SHOR DEVELOPMENT

SSD RESPONSE

25.04.18

1.0 Response to Government Architect's Office Commentary

190311S-SSK-004-L

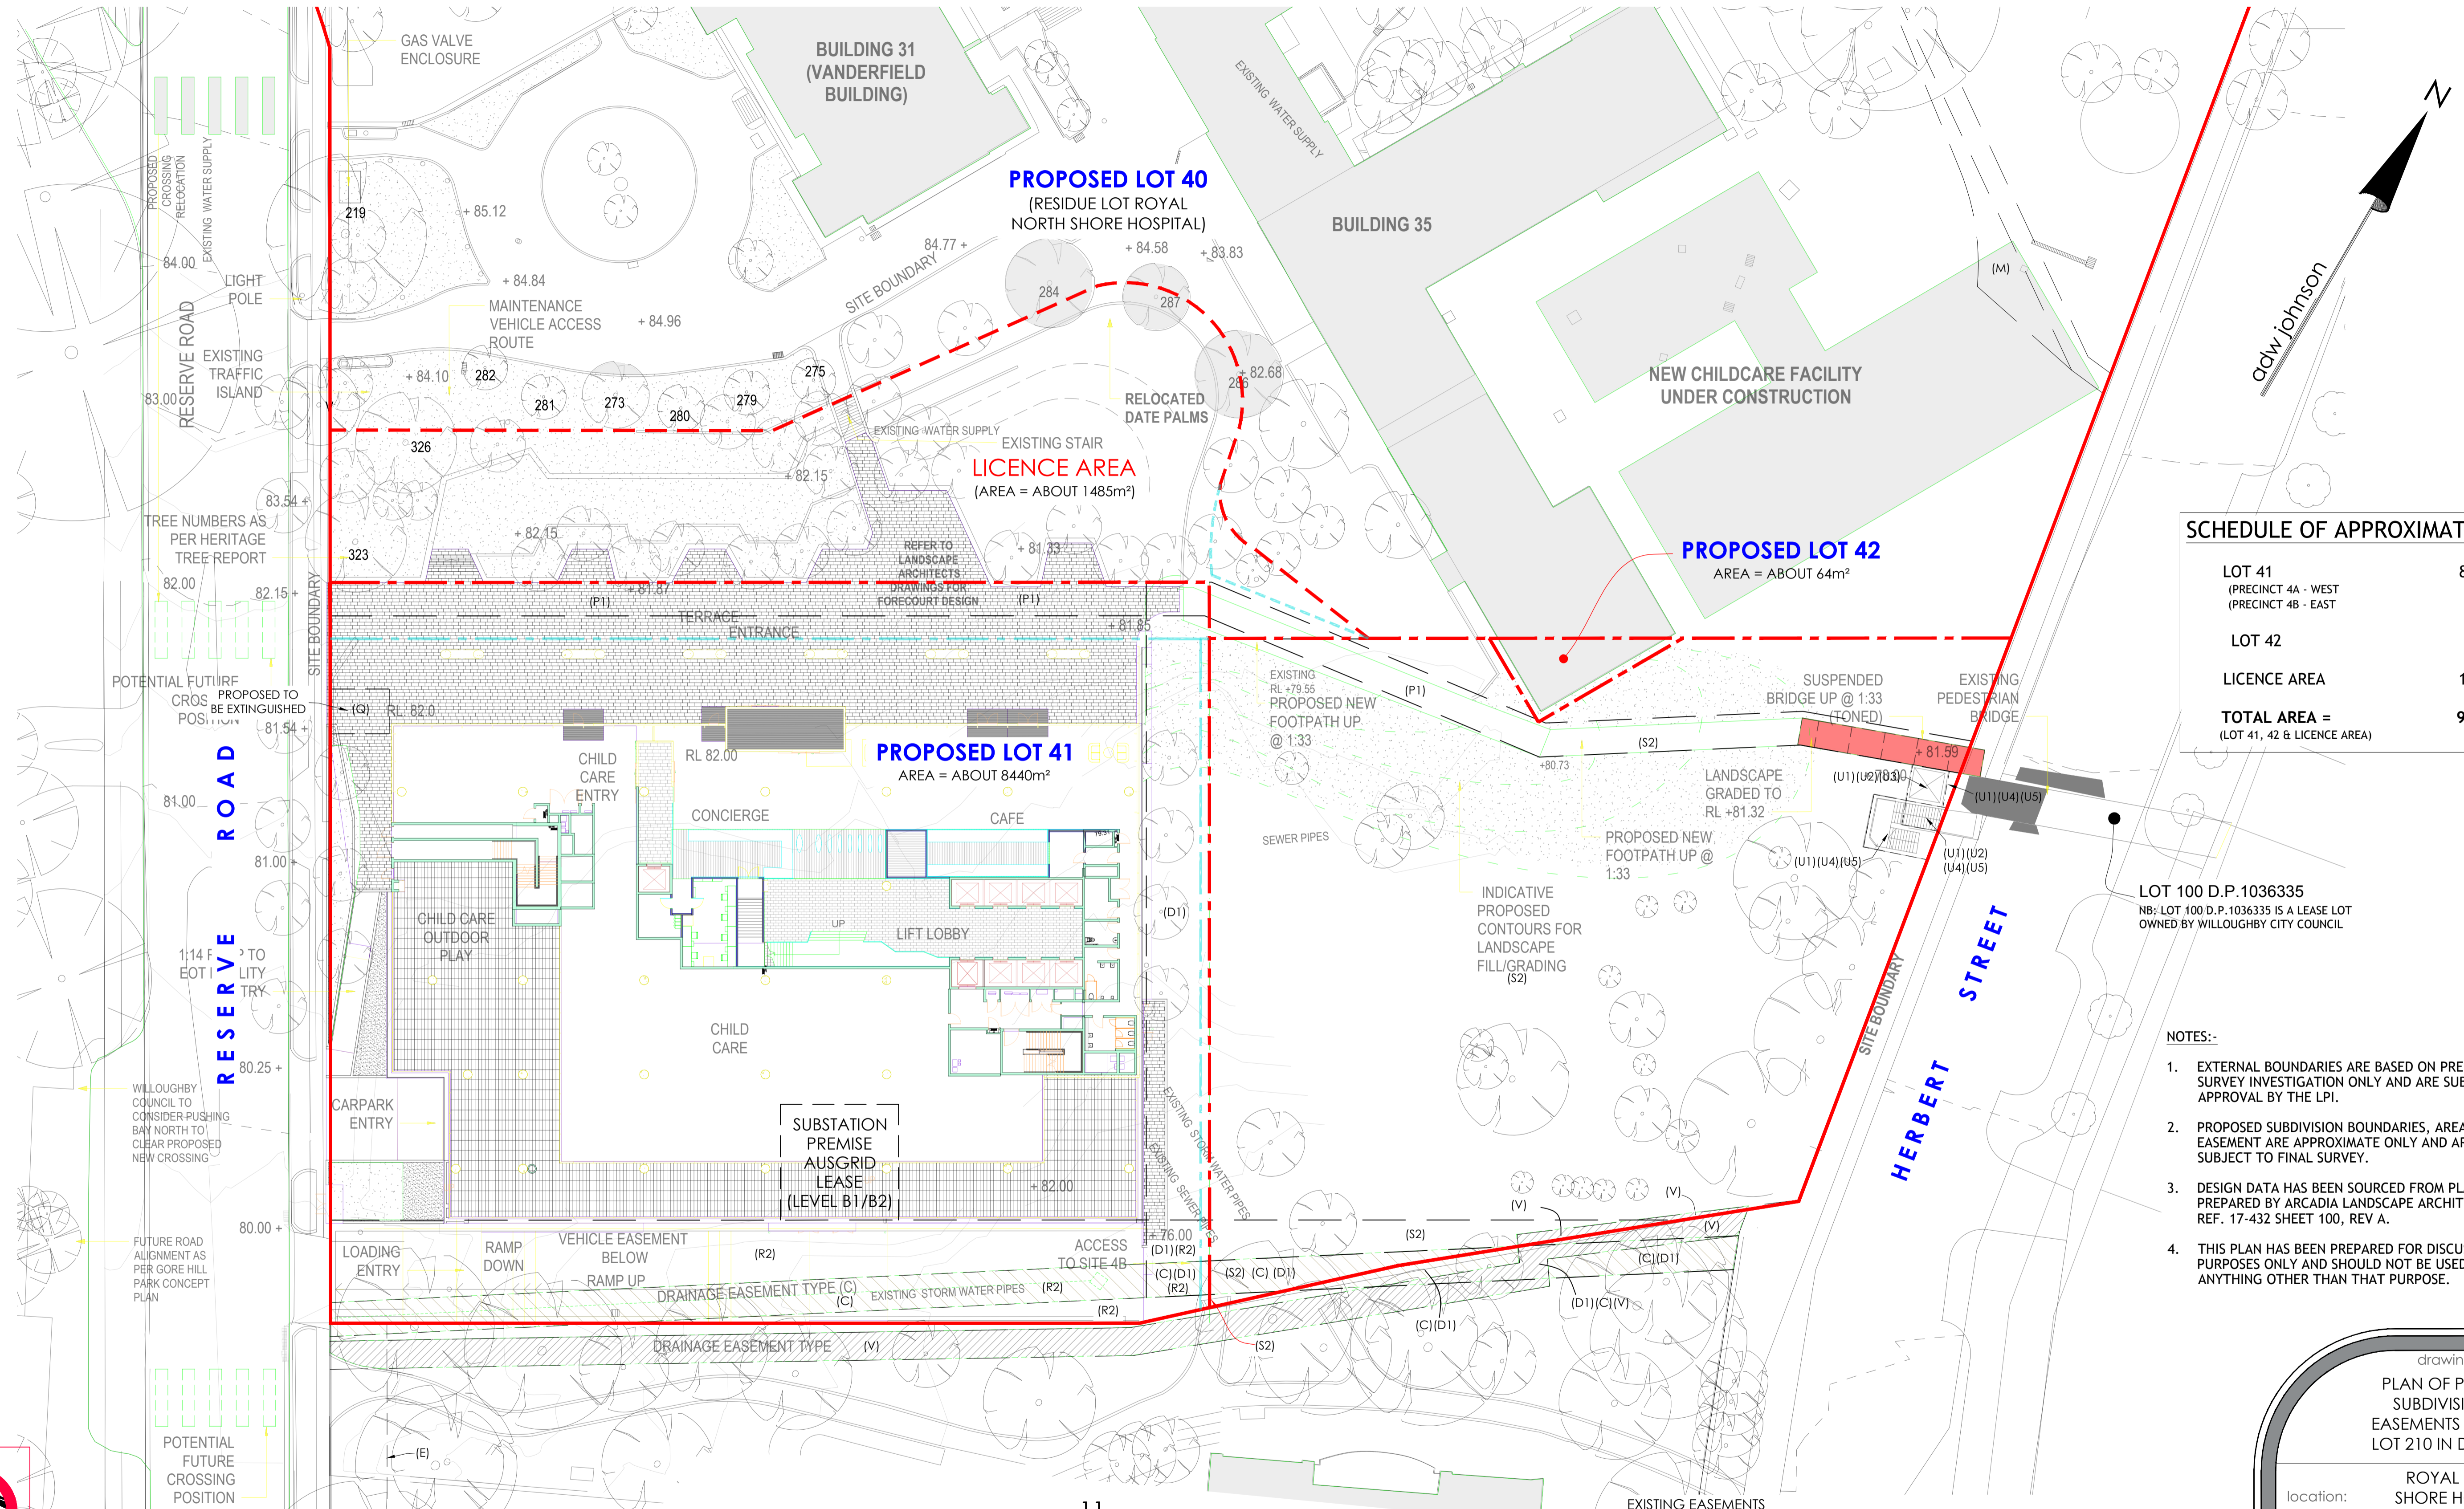
2.1 SUBDIVISION

- The new boundary subdivision at the north of Site 4 at Building 36 is formed by Building 36's south-western corner. The building will meet the fire rating requirements required by the BCA along this boundary.
